## **Thanet Extension Offshore Wind Farm**

Appendix 28, Annex D to Deadline 1 Submission:  
Minutes with MCA from October 2018

**THANET EXTENSION MEETING MINUTES – SHIPPING AND NAVIGATION**

<b>MEETING ORGANISER:</b>	VATTENFALL WIND POWER LTD
<b>MEETING DATE</b>	4 <sup>TH</sup> OCTOBER 2018
<b>ATTENDEES:</b>	DAN BATES (VWPL) SEAN LEAKE (GOBE CONSULTANTS) ED ROGERS (MARICO) JAMIE HOLMES (MARICO) HELEN CROXSON (MCA) TREVOR HARRIS (TRINITY HOUSE) STEPHEN VANSTONE (TRINITY HOUSE)
<b>APOLOGIES/MEMBER NOT REQUIRED FOR PARTICULAR MEETING:</b>	MIKE VANSTONE (VATTENFALL) ROGER BARKER (TRINITY HOUSE)

Sea Zones Plan – Reduction in red line boundary

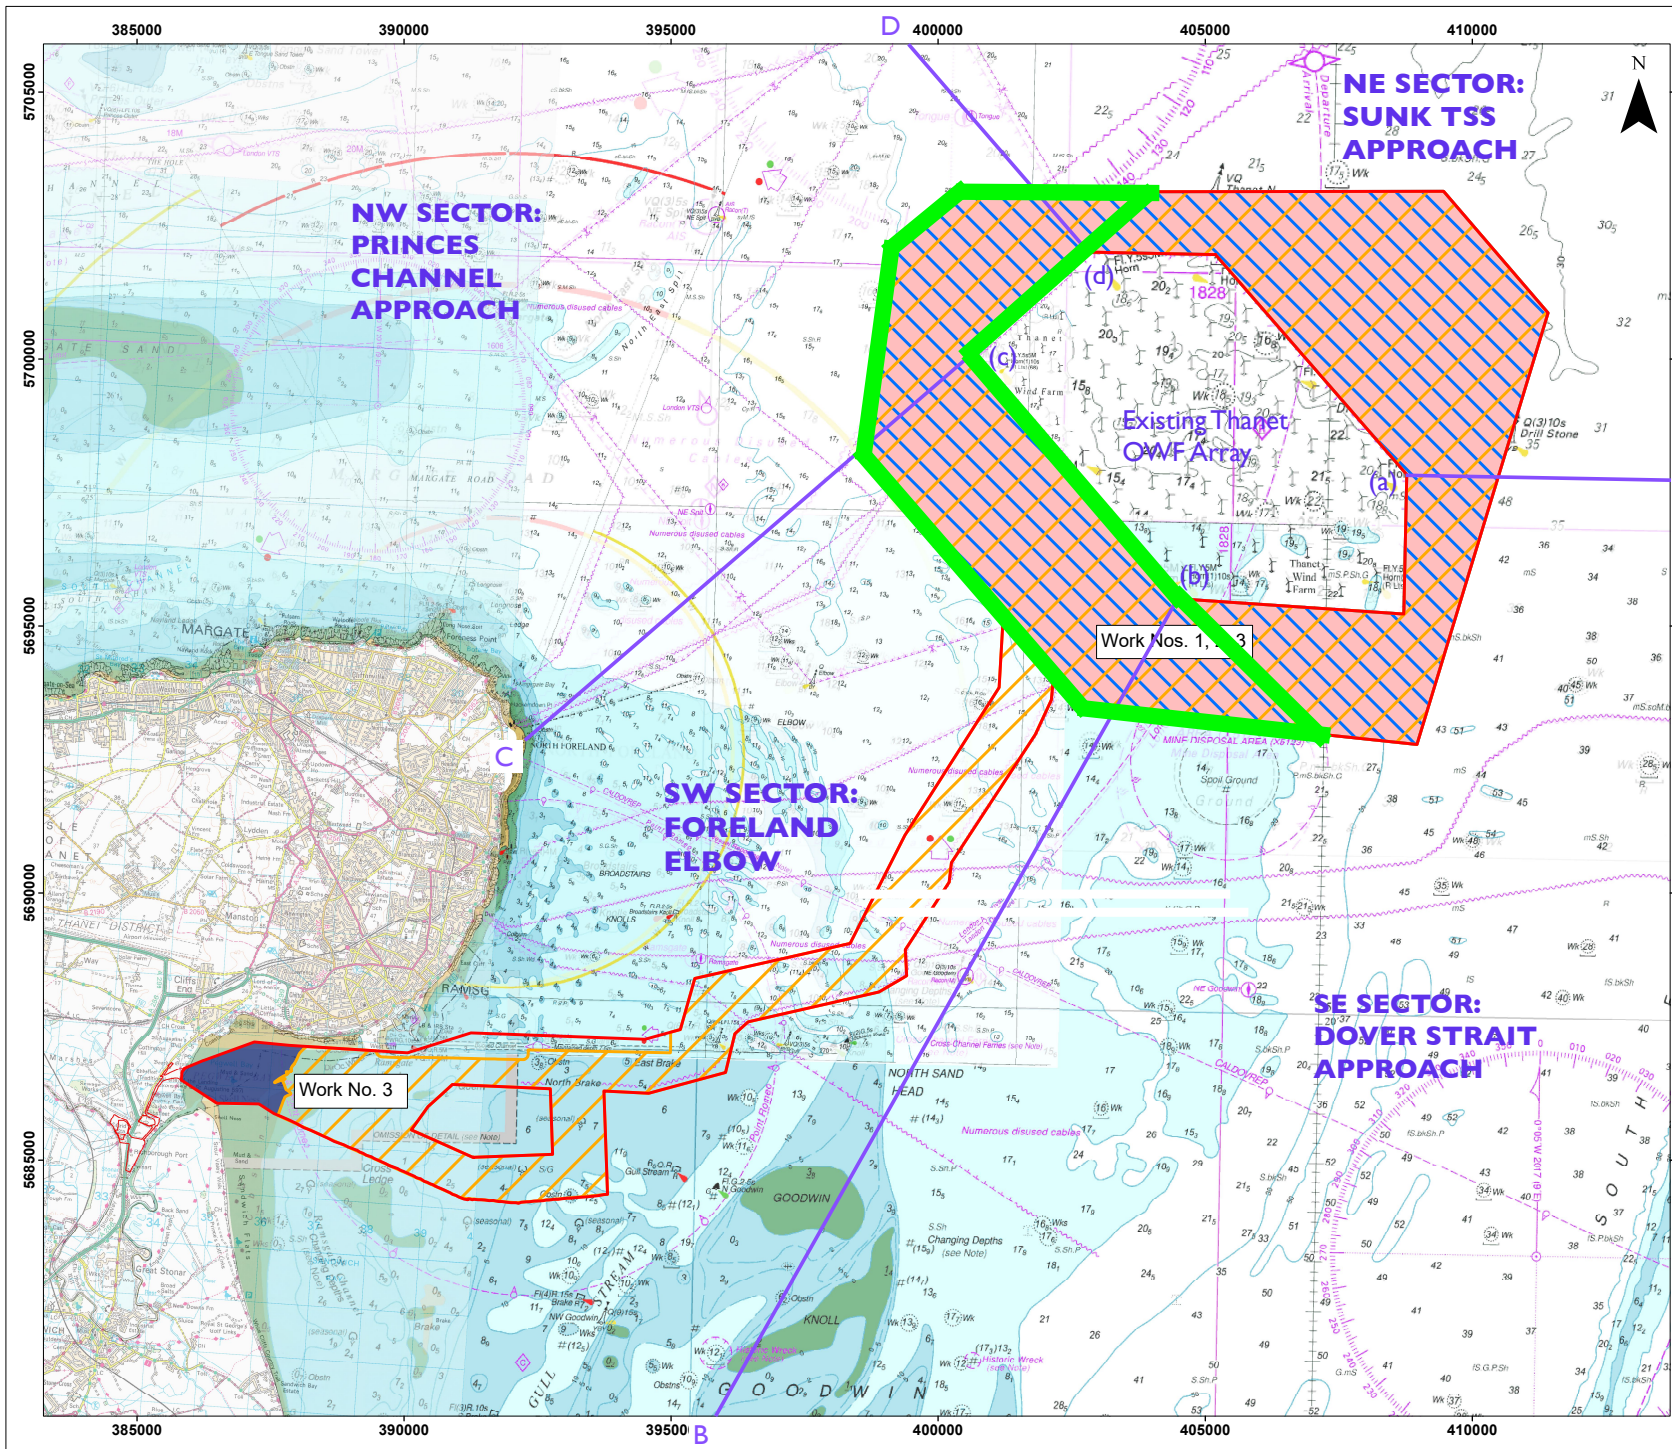
- Commented [HC13]:** MCA has already made it clear that the small change to the redline boundary was not to the extent we expected to change our view.

- Commented [TH14]:** Trinity House did welcome the small change already made. However this change did not reduce our concerns on the navigational safety aspects of the project.

**Commented [HC31]:** We have considered what action will address our concern and that would be a significant change to the redline boundary on the western extent, to the satisfaction of its stakeholders.
